LIFT STATION #1 REPLACEMENT

LANDSCAPING PLAN & NOTES

PCD File No. PPR1841

C18
SHEET 18 OF 19

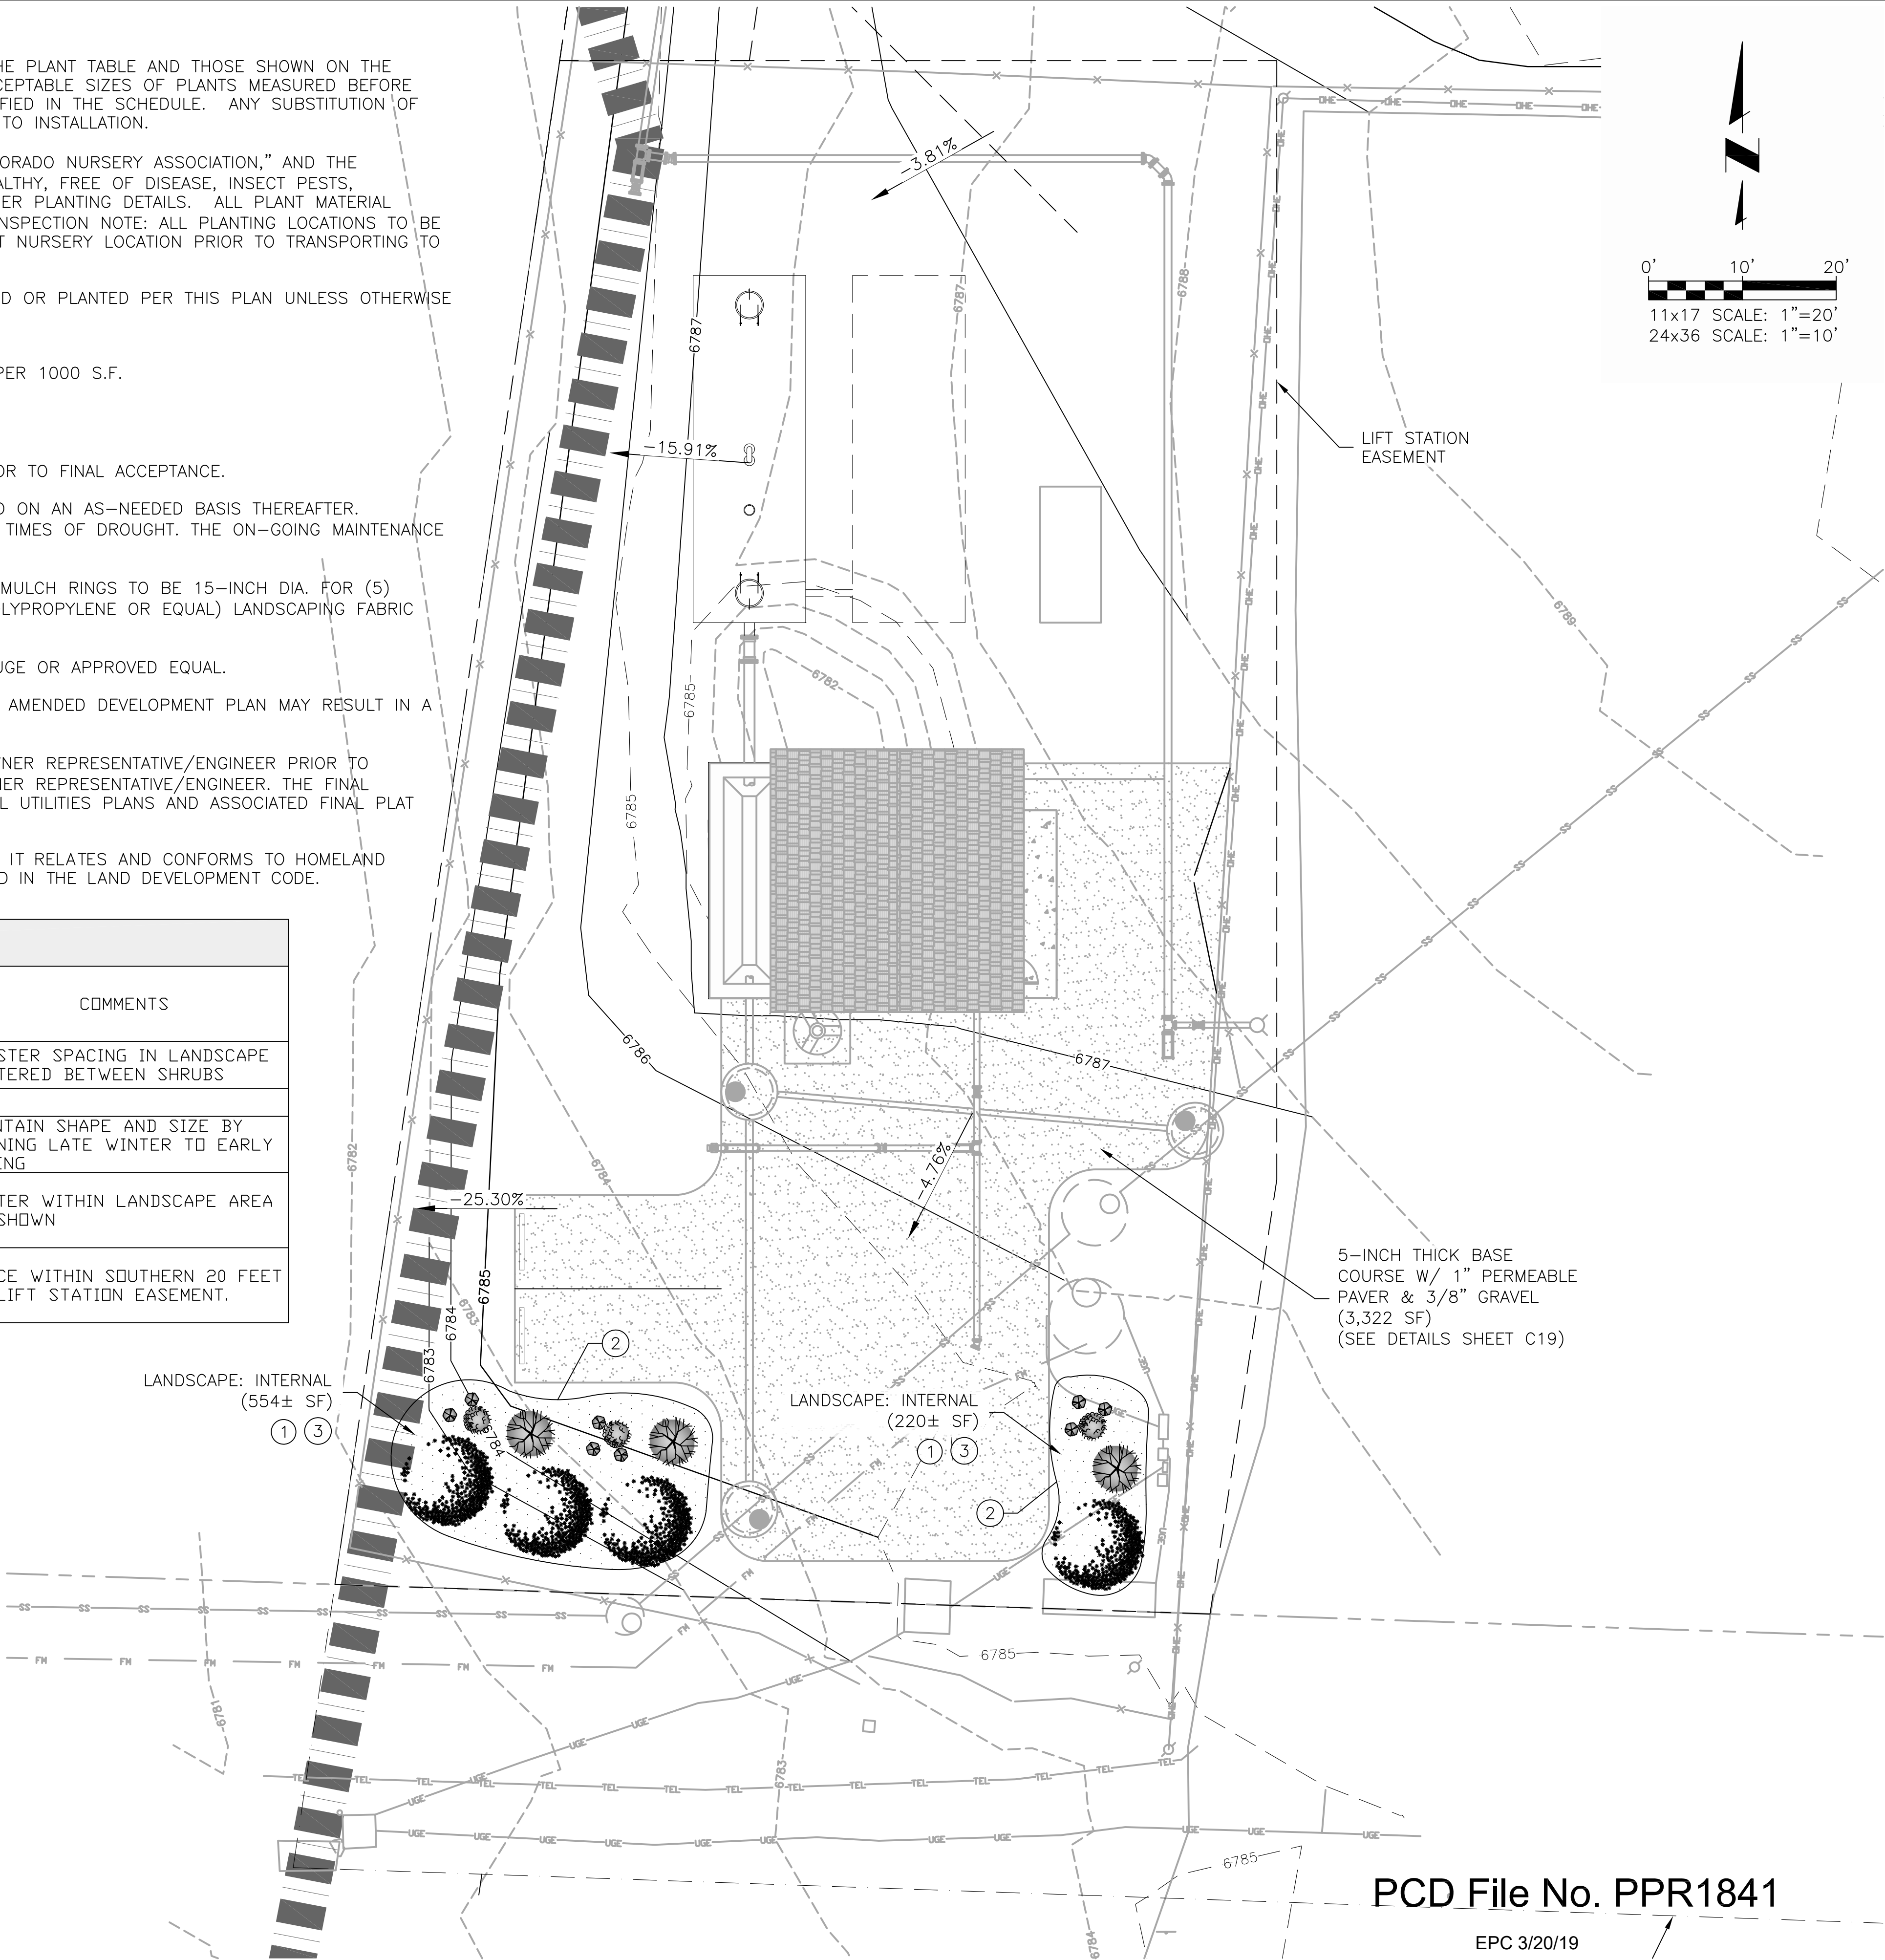
One tree per 500 sf of internal is required. The plan shows that the 4 trees are for internal landscaping. If they are for roadway landscaping as the table suggests, mark them on the plan as roadway landscaping.

The roadway landscaping requirement is within 20 feet of the roadway, if this is not possible, mark in the letter of intent that you are requesting an alternative landscaping plan, and mark this plan as "Alternative Landscaping Plan".
